Land at Drove Lane, Yapton
Surface Water Drainage Statement Addendum

(Document ref. 133647-SWDS-01C)

This updated addendum is to be read in conjunction with Document Reference: 133647-SWDS-01A and all relevant drawings to support the reserved matters application for the development site at Drove Lane, Yapton.

Drawn	Date	Checked	Date	Approved	Date
SM	15.01.2021	MFP	15.01.2021	MFP	15.01.2021
Scale	AS NOTED	Orig Size	A1	Dimensions	Metres
Project No.	133647	Drawing File	PLN_1_4085 SuDS Sections.dwg		
Drawing No.	PLN-1-4085			Rev.	C

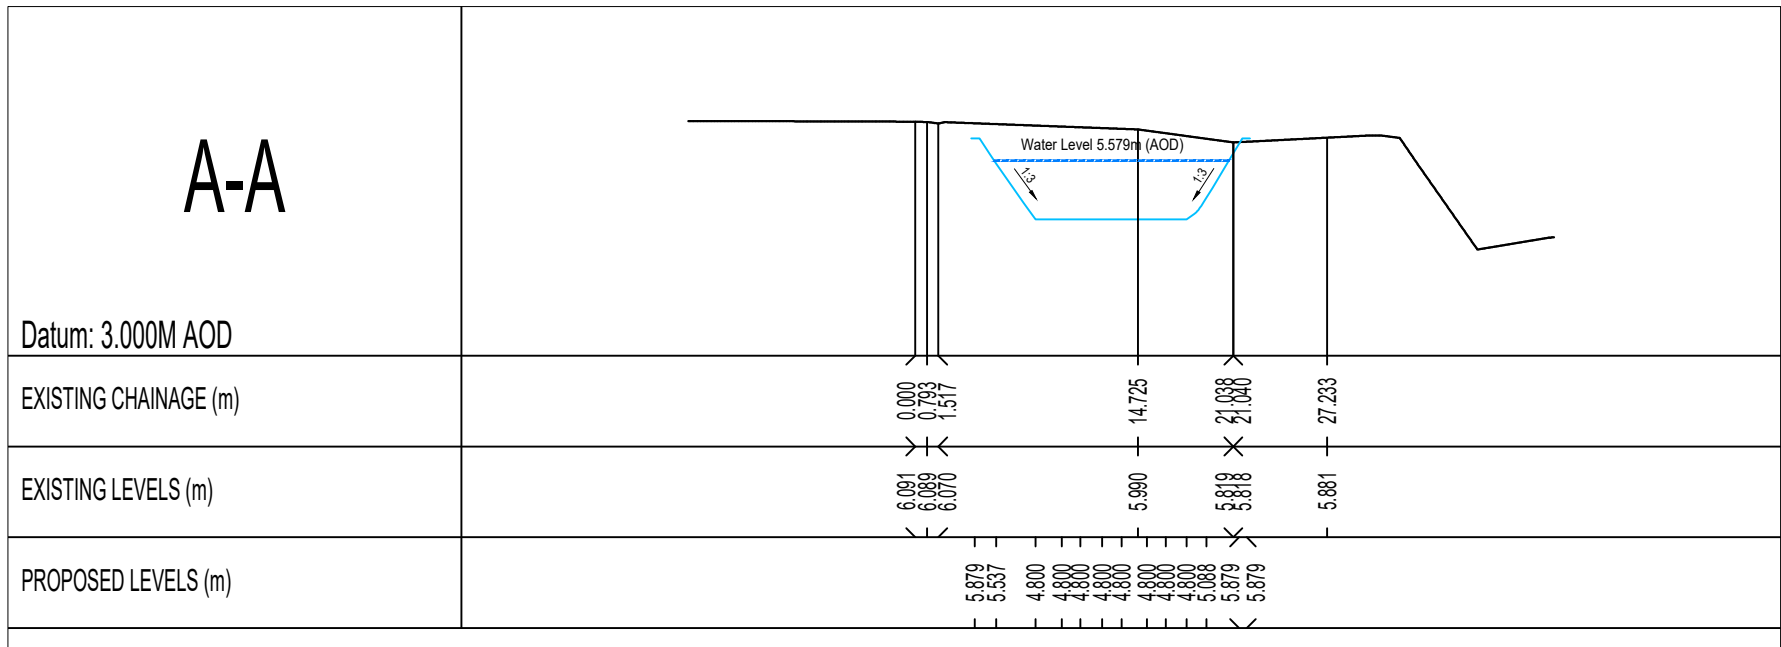
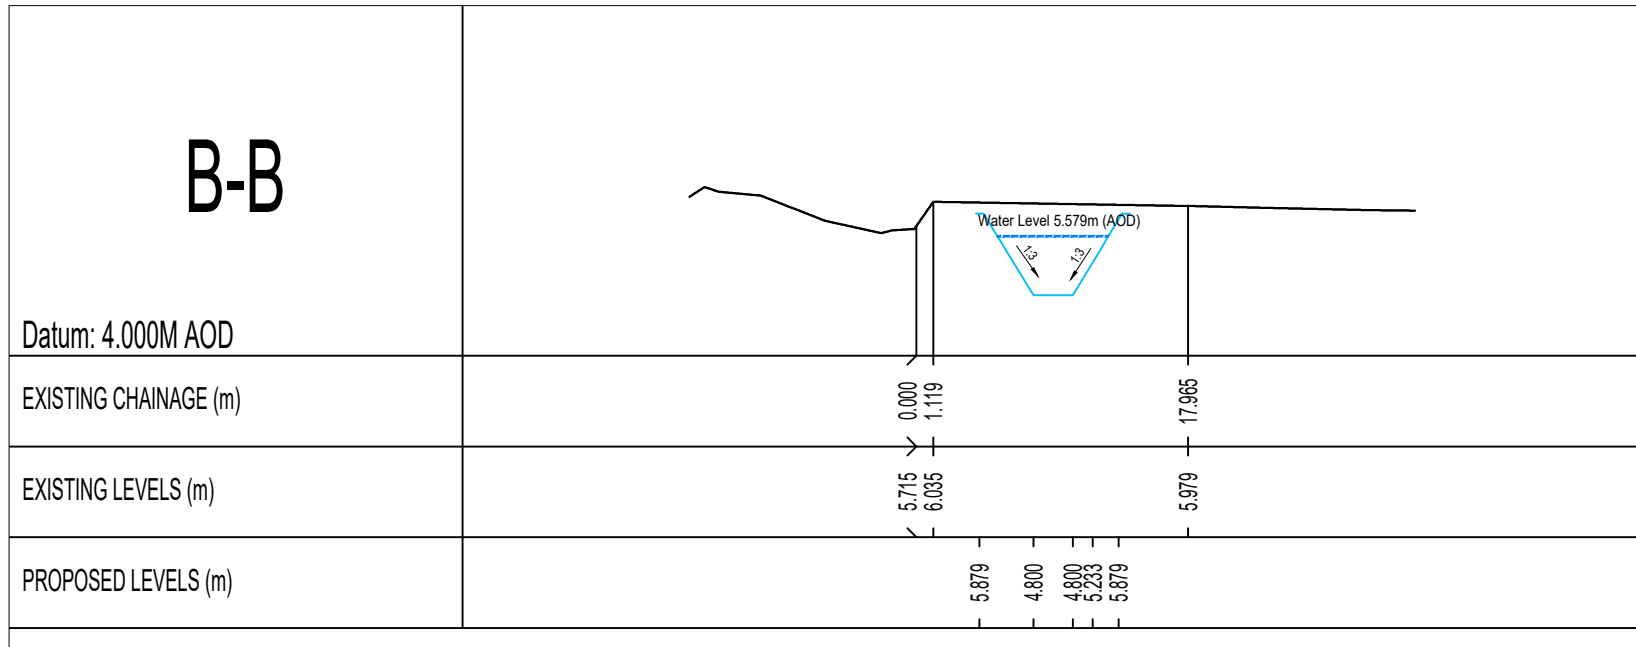
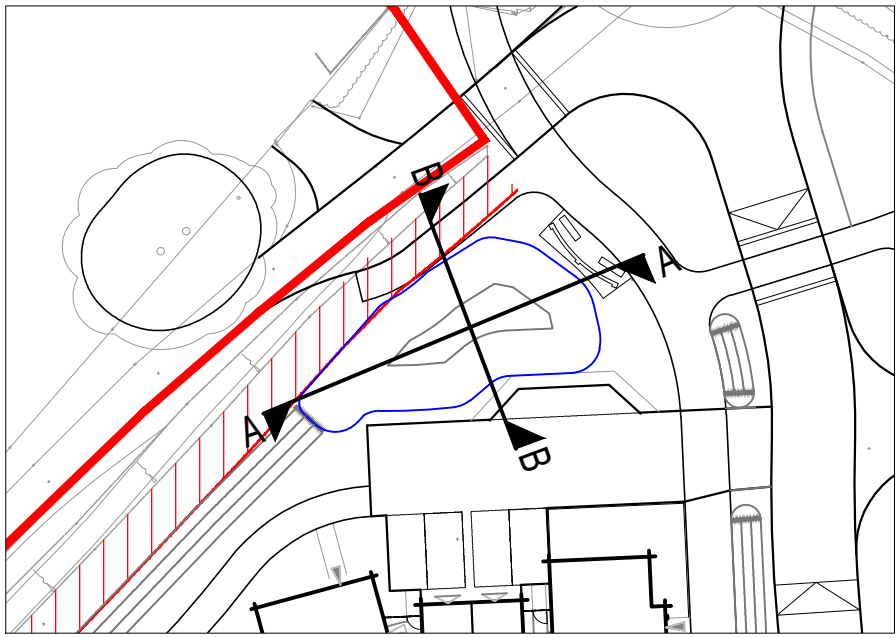
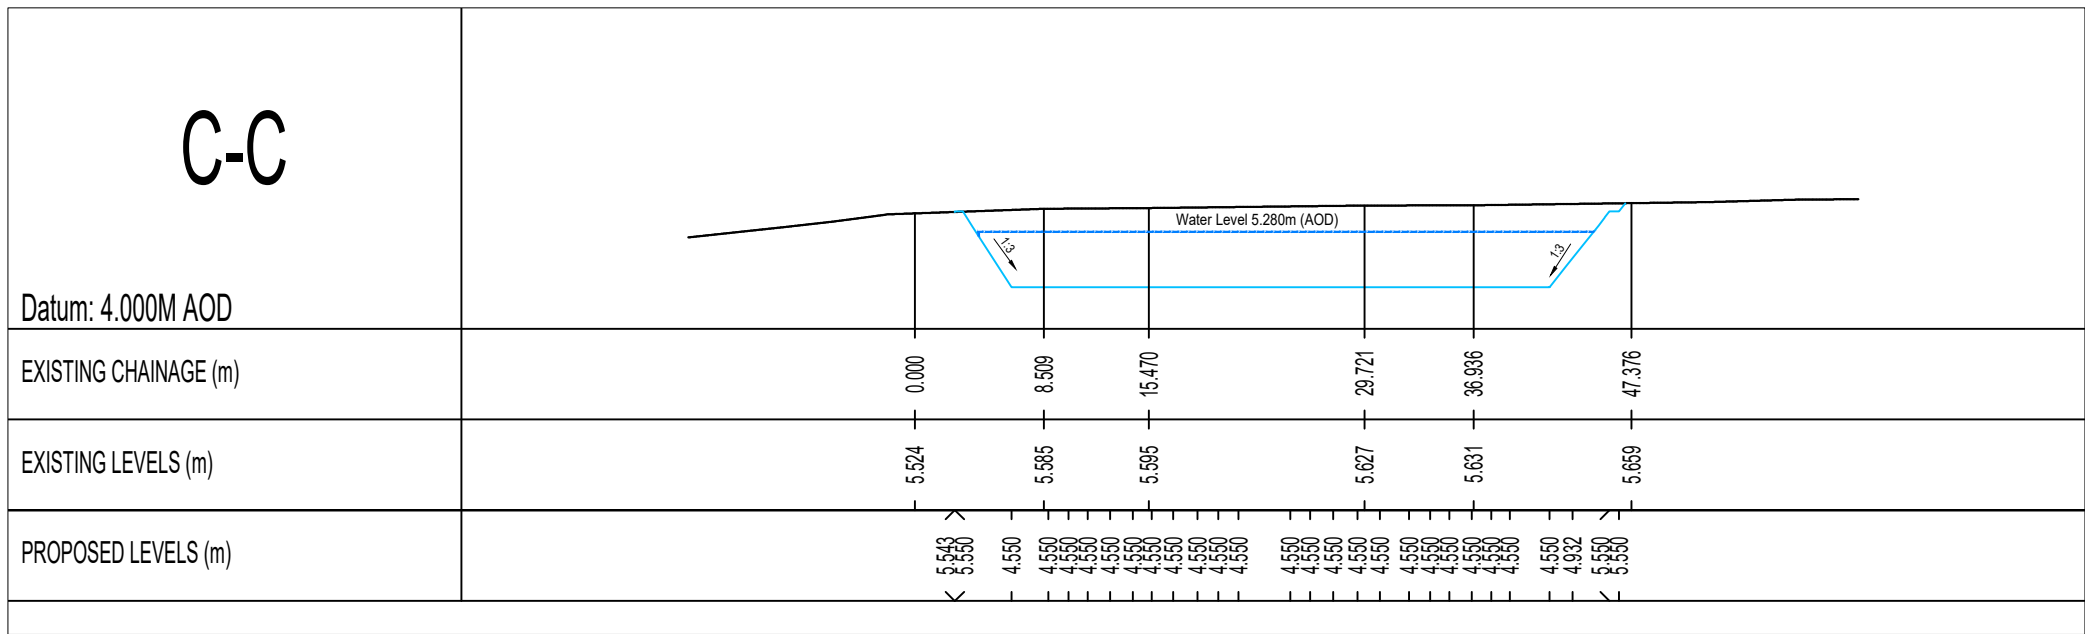
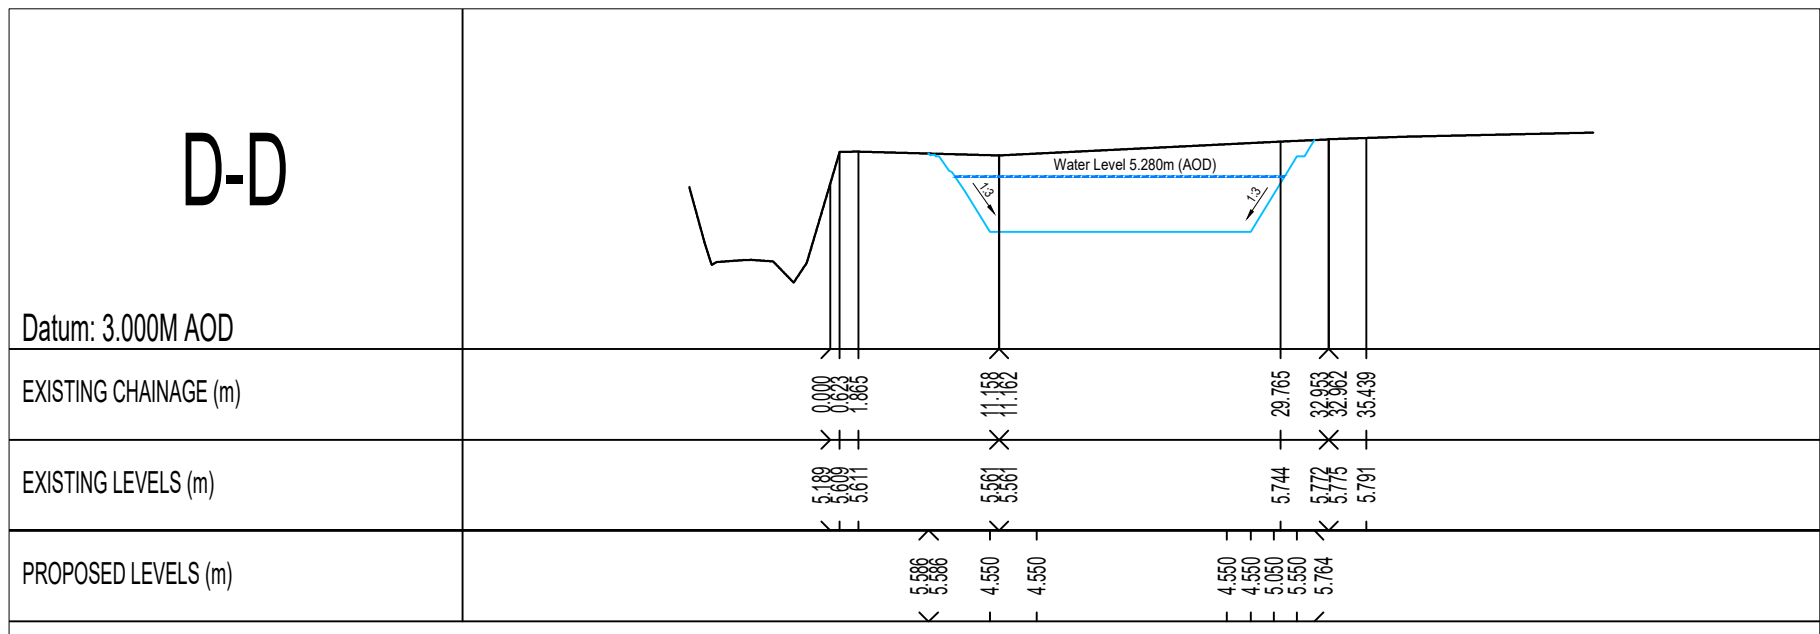
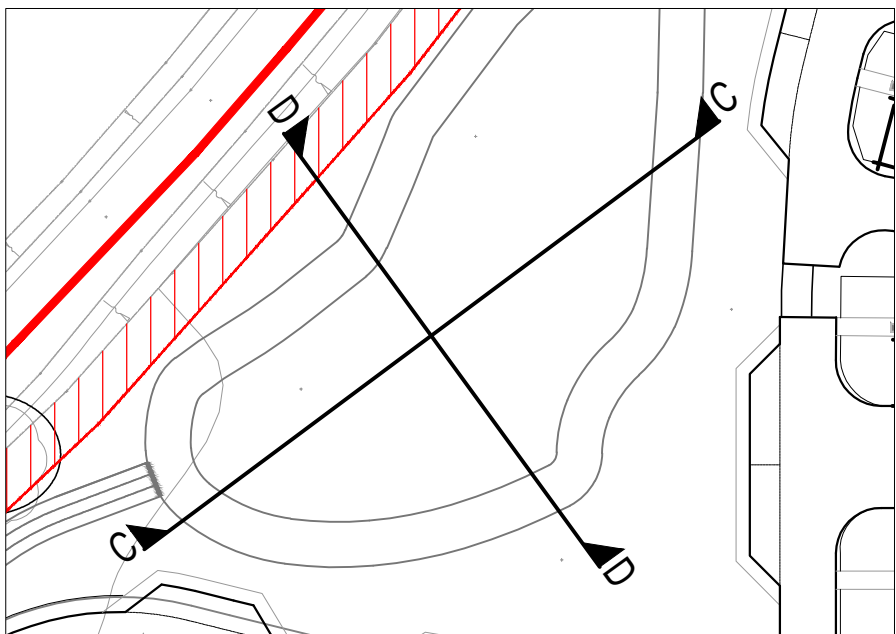
- ¿ Two cross sections in perpendicular directions through each SuDS pond have been issued with the updated application. The contractor will be provided with setting out coordinates and levels to ensure that the ponds are constructed with correct bed, bank and side slopes at the construction stage.
